NOTIFICATION FROM ARUN DISTRICT COUNCIL

APPLICATION P/25/11/
NO:

Registered: 28-MAR-11
Site 3 Old Barn Close Mill Farm Pagham
Address:

Category: Plan Applicat'n
Description of Works: Conservatory extension

sheet 1a of 2

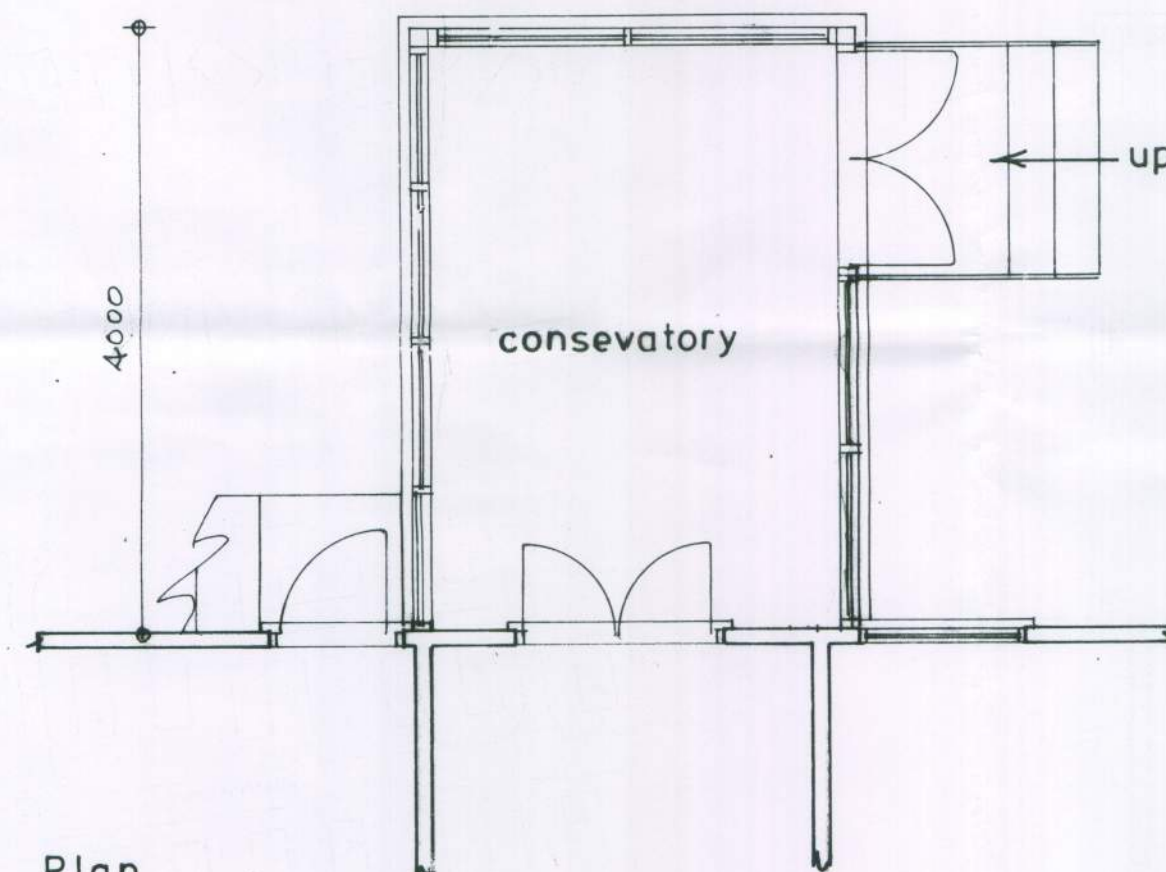
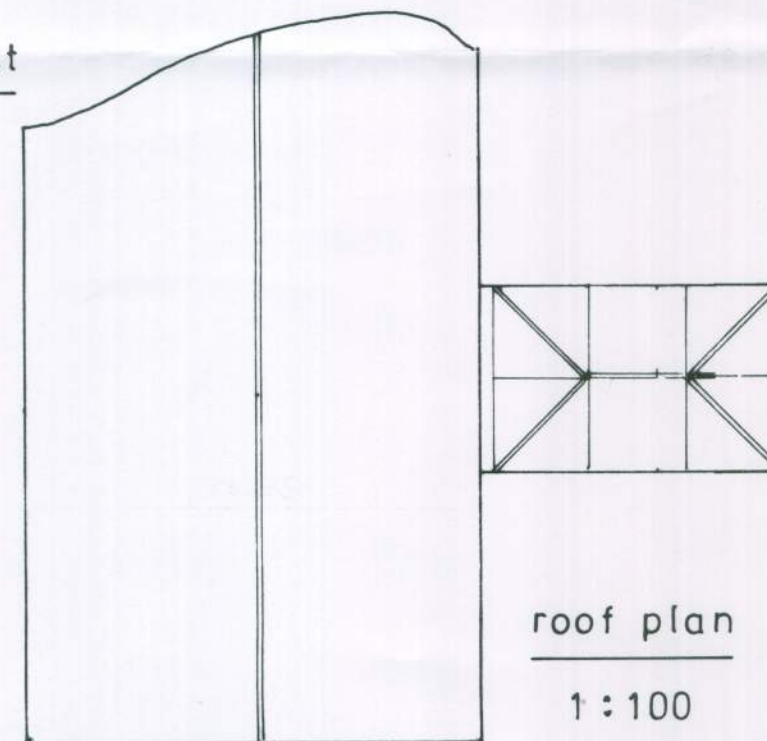
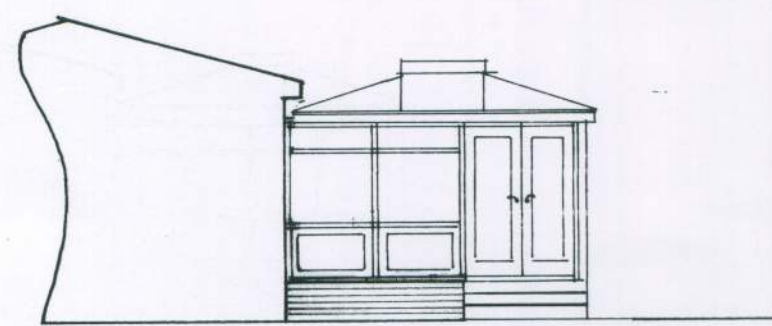
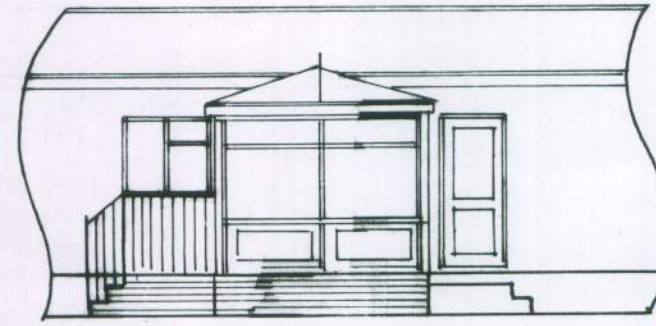
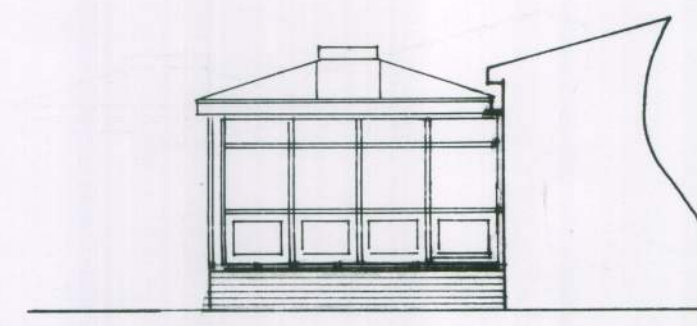
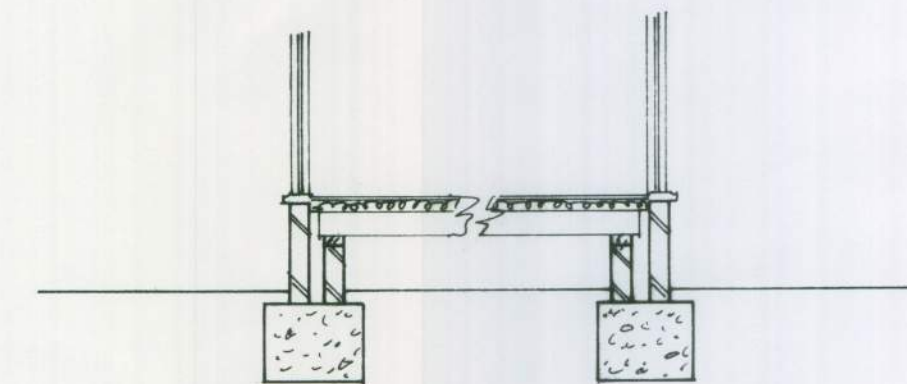
- 1) This application relates to land that is not owned by the applicant. The site is owned by Deerhyde Ltd.
 2) The proposed conservatory proposes to increase the width of the park home beyond that allowed by legislation (Max Size 60' x 20' x 10' max ht (18.288m x 6.096m x 3.048m)

Therefore the application cannot be supported
